DEVELOPMENT REVIEW BOARD
SUPPLEMENTAL SUBMITTAL

PROJECT NO. PR-2018-001405
Application No. SD-2022-00100

SUBMITTAL DESCRIPTION: Added easements [14] and [17] for private waterline per ABCWUA and

Re: Final Plat Review for Proposed Subdivision of Tract B, Nuevo Atrisco

**Plat for
Tracts B-1, B-2, and B-3
Nuevo Atrisco
Being Comprised of
Tract B
Nuevo Atrisco
City of Albuquerque
Bernalillo County, New Mexico
June 2022**

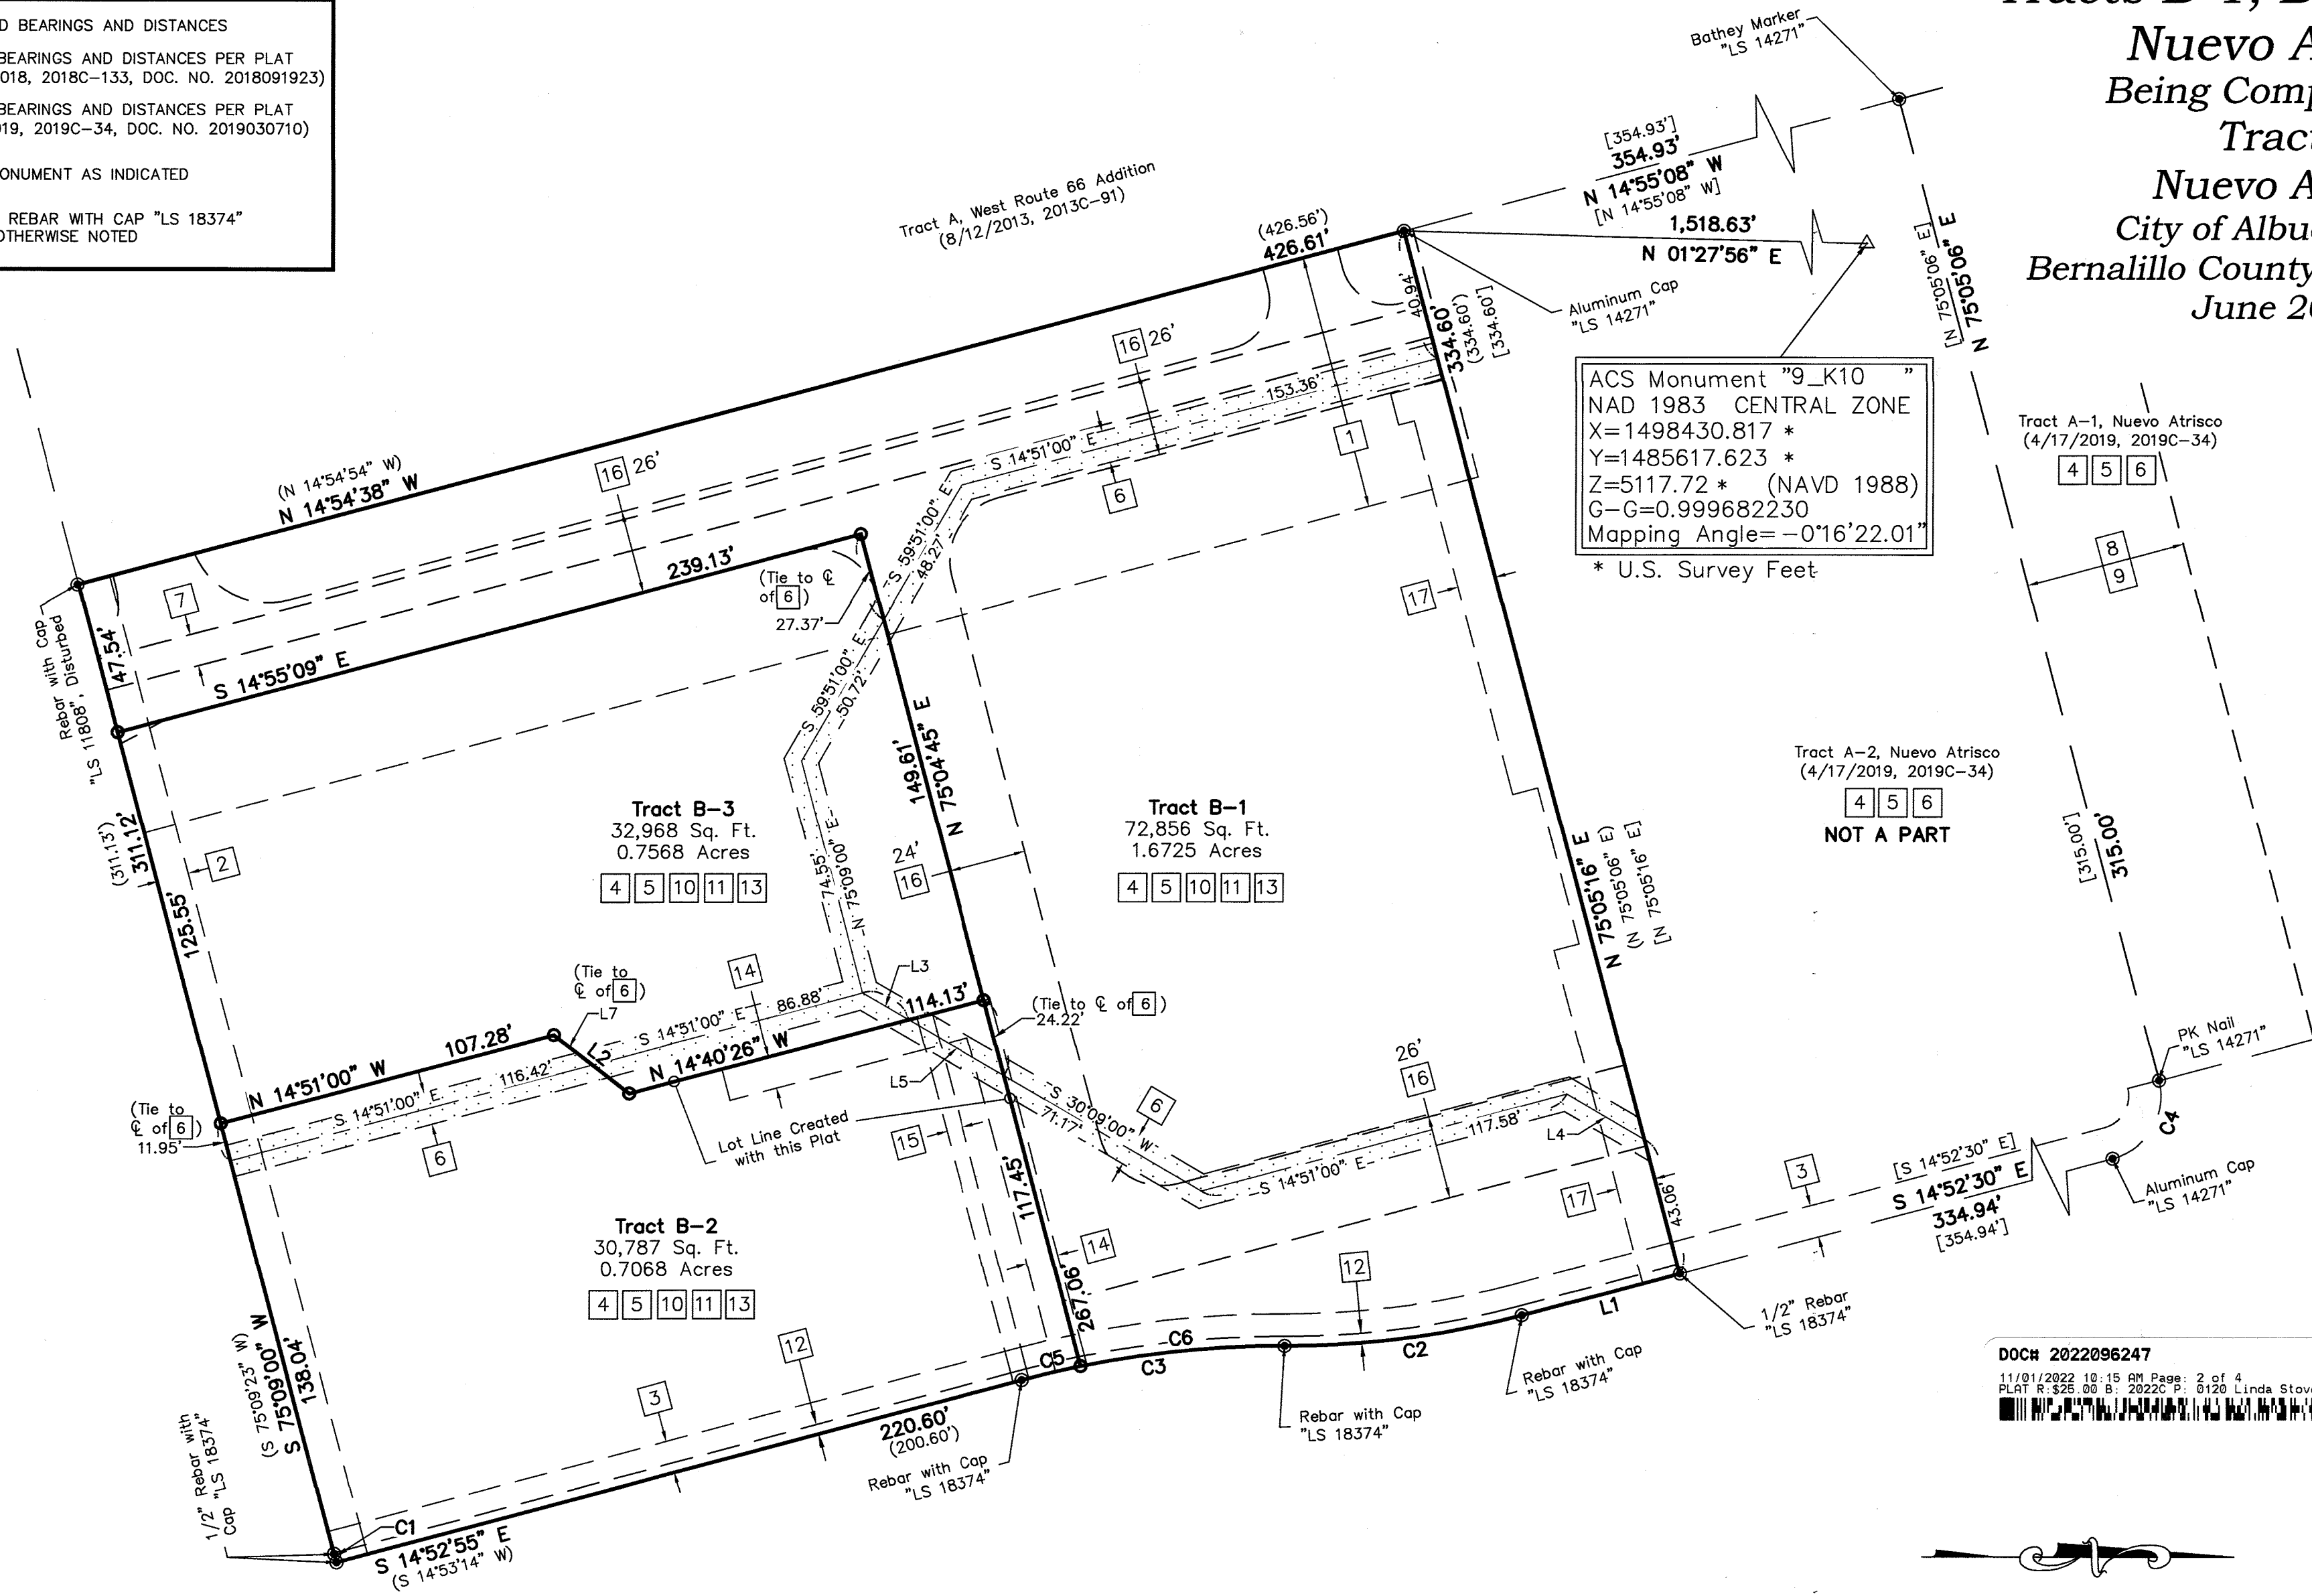
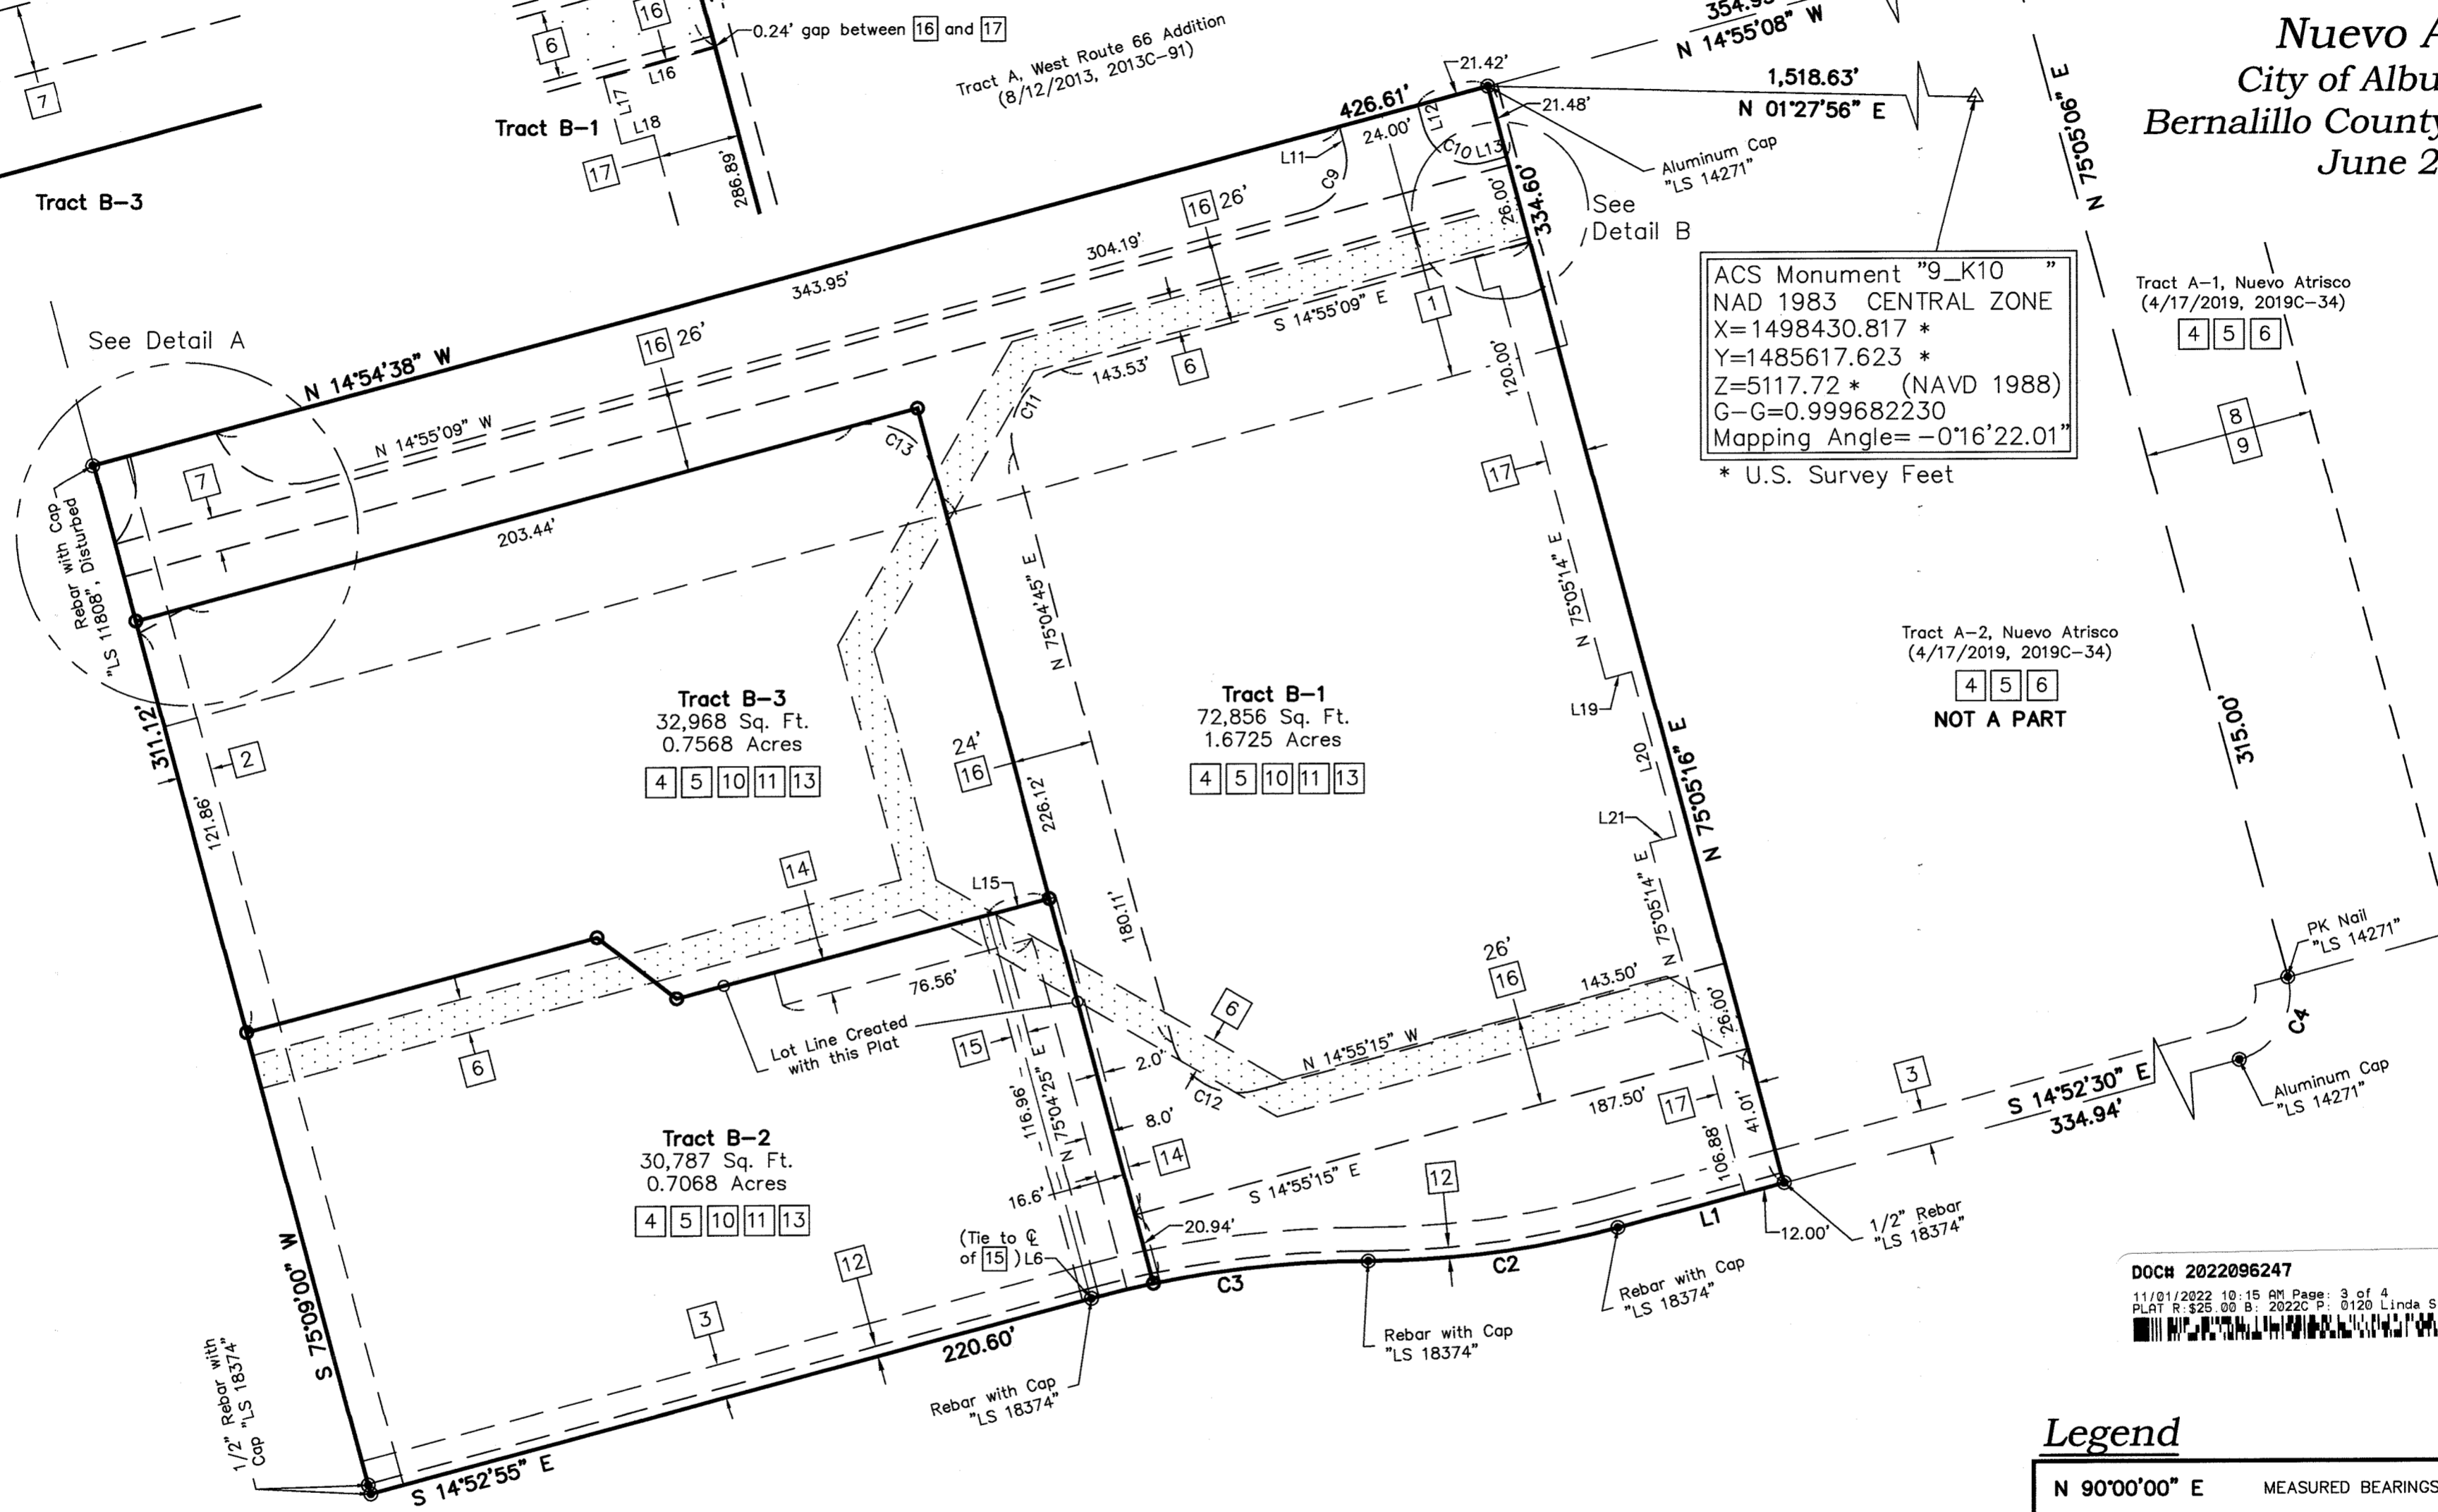
1. A private sewer easement across Lot 2 benefitting Lot 3 is required.

2. The lot to the north requires a private water easement for the fire line serving that lot.

Noted, easement [14] has been added back to the plat to provide water across lot 2 for lot 3.

Noted, easement 17 had been added to the plat to provide service to north adjoining Tract A-2.

SHEET NO.
SDP2.1

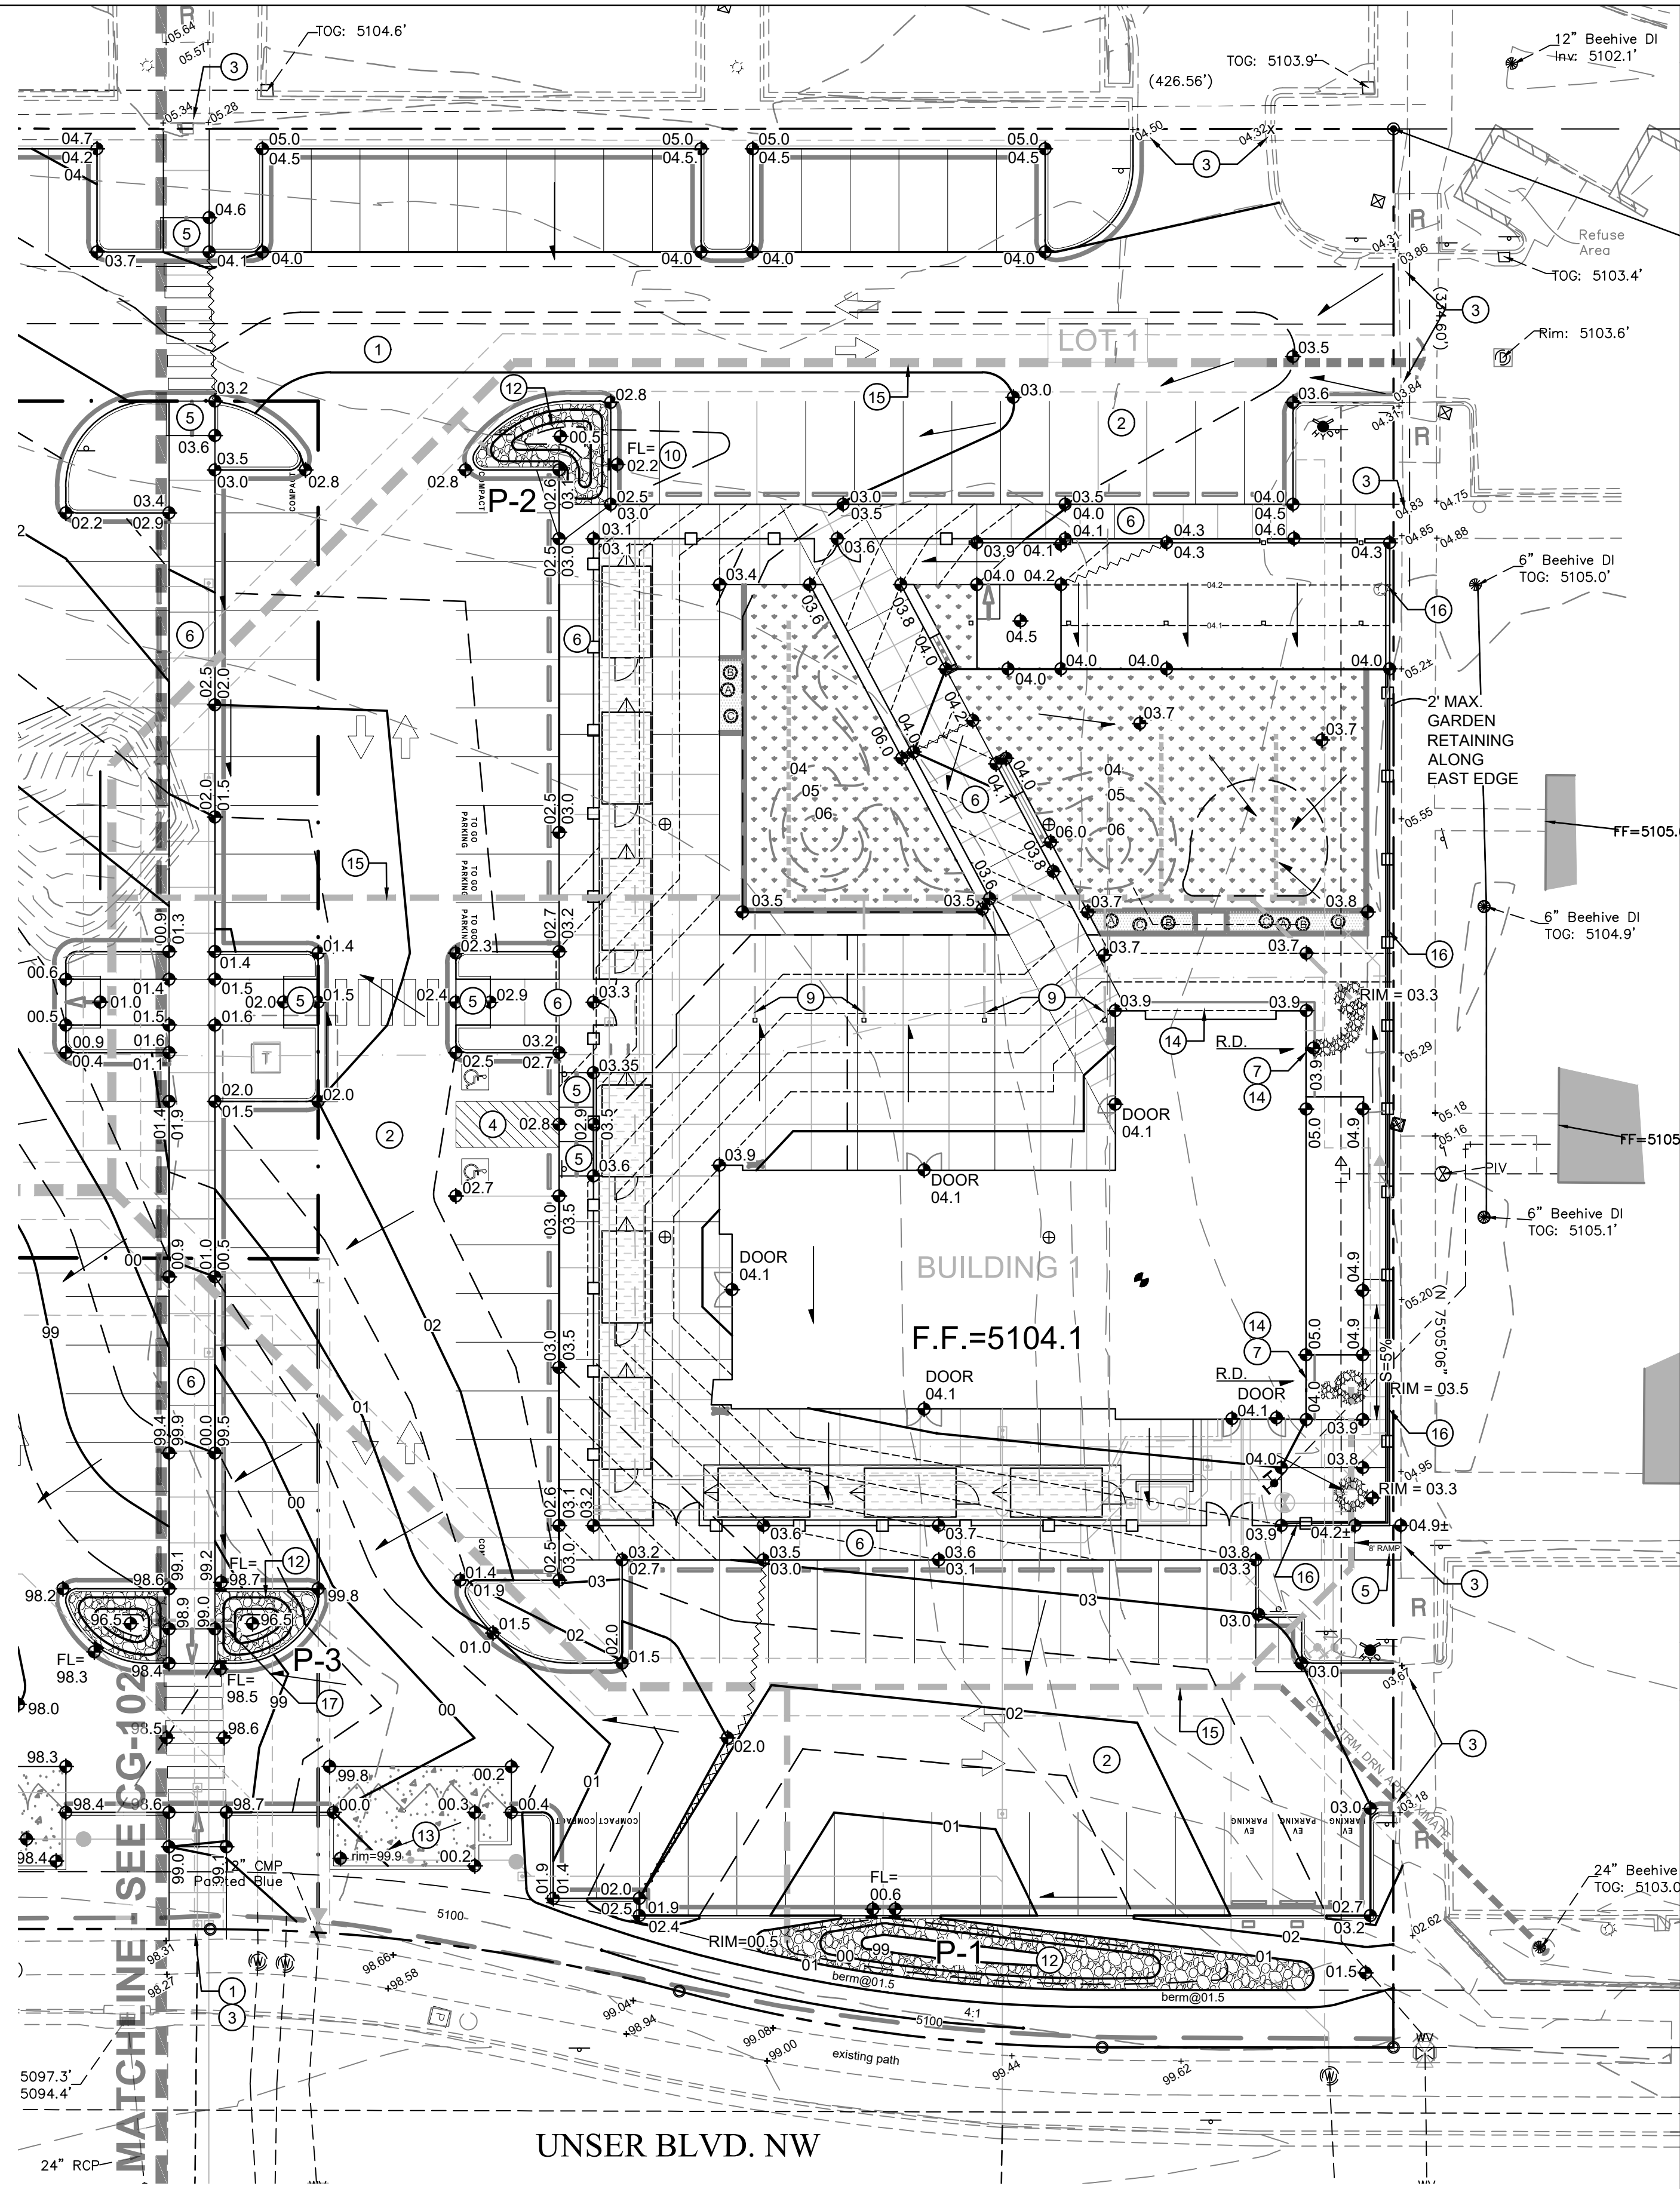
No objection to the requested replat. Central Ave NW is a Community Principal Arterial and a Proposed Pedestrian Project per the MTP 2040; Unser Blvd NW is a Regional Principal Arterial; both require street trees upon applicable development per IDO Section 5-6(B).

Applicant added street trees to Unser Blvd and Central Ave in front of Building 2. Central Avenue has a major storm drain, so trees cannot be added in front of Building 3, and the applicant provided additional shrubs / desert accents since the last submittal. Tree species are appropriate. No further comments.
